**South32 – Illawarra Coal**  
**Dendrobium Mine: Plan for the Future**  
**Application**

**KA Peer Review of HydroSimulations**  
**Groundwater Modelling Assessment**

**Dr F. Kalf**  
**B.Sc. M.App.Sc Cert. Eng. Hydrology, PhD.**  
**30 April 2019 (V8)**

Graph 6-1 Plot Showing the Ranges of Electrical Conductivity for Various Water Sources [Figure 4-16 from HydroSimulations, 2019]

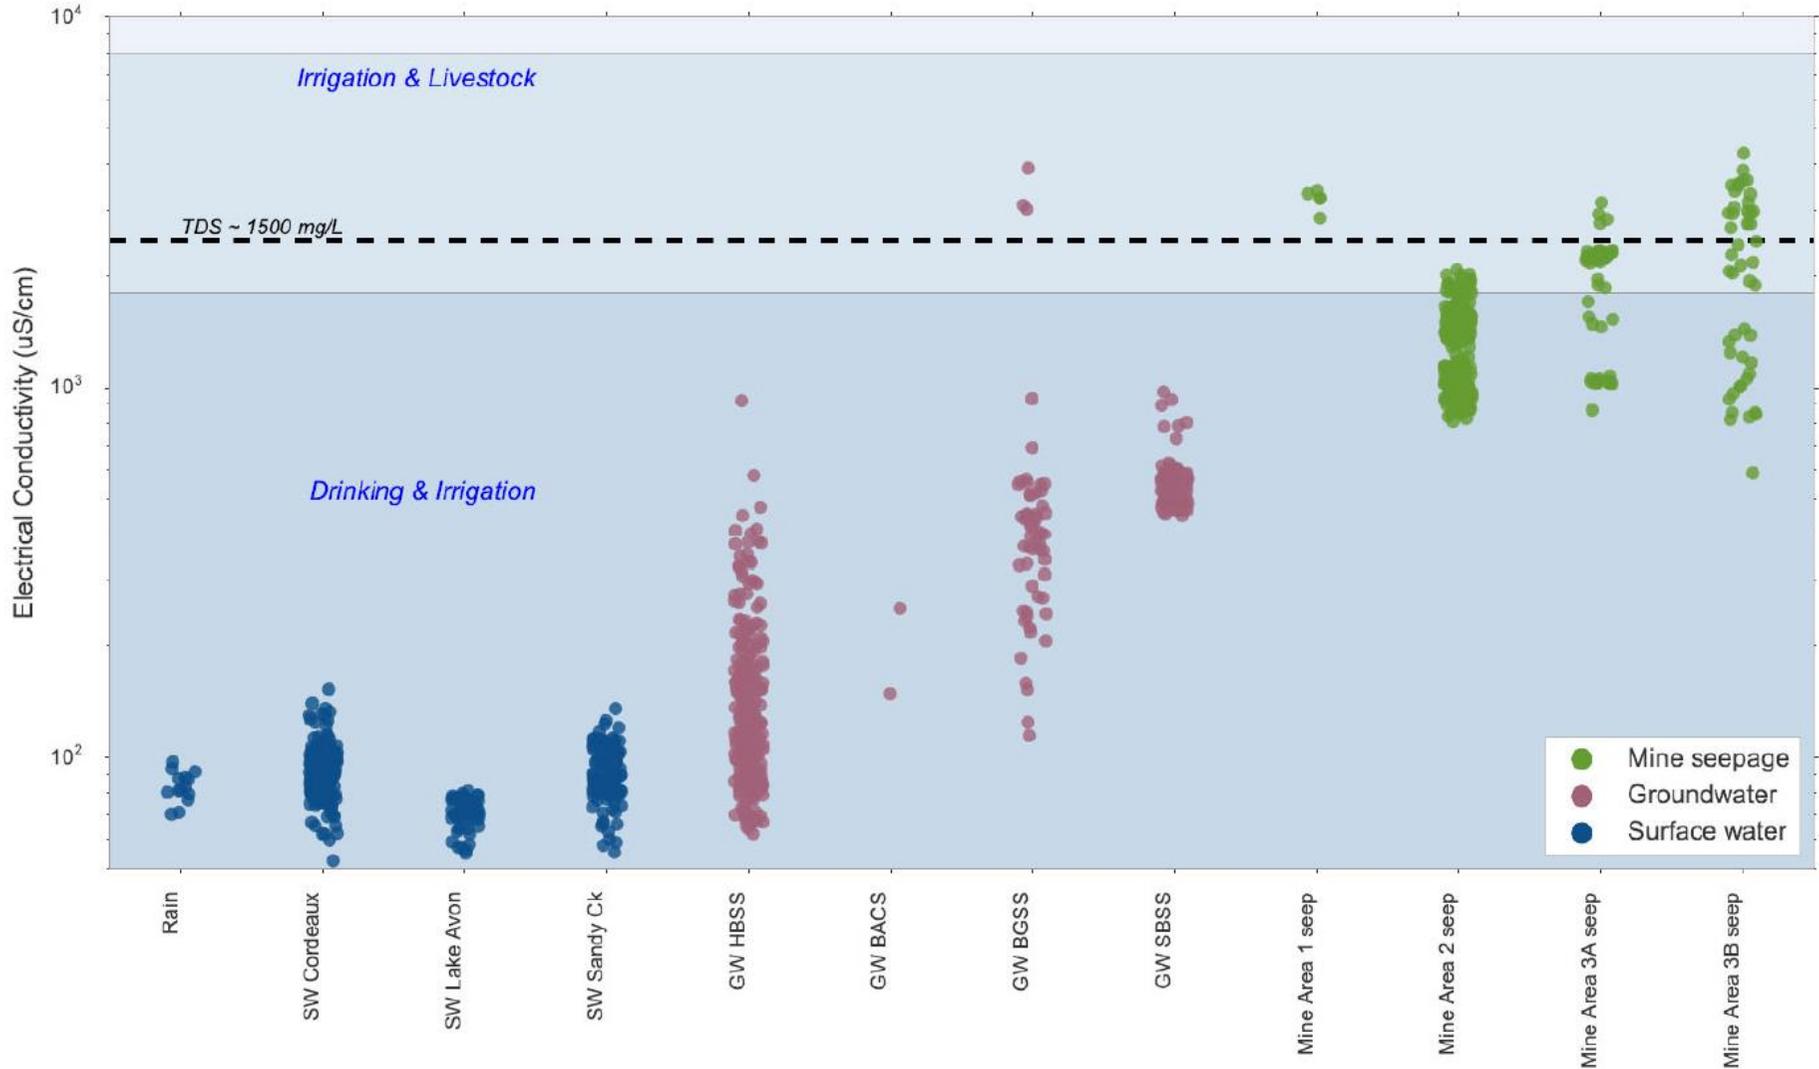
Groundwater quality is outlined in their Section 4.5. Since 2004 3,200 water samples (that included surface water) have been analysed at the Dendrobium mine site. Groundwater salinity increases with depth in the geological sequence but the bulk of samples have a salinity less than 1500 mg/L ( Figure 4-16) indicating a proportion of mine seepage having salinity in excess of 1500 mg/L (i.e. 2500  $\mu$ S/cm).
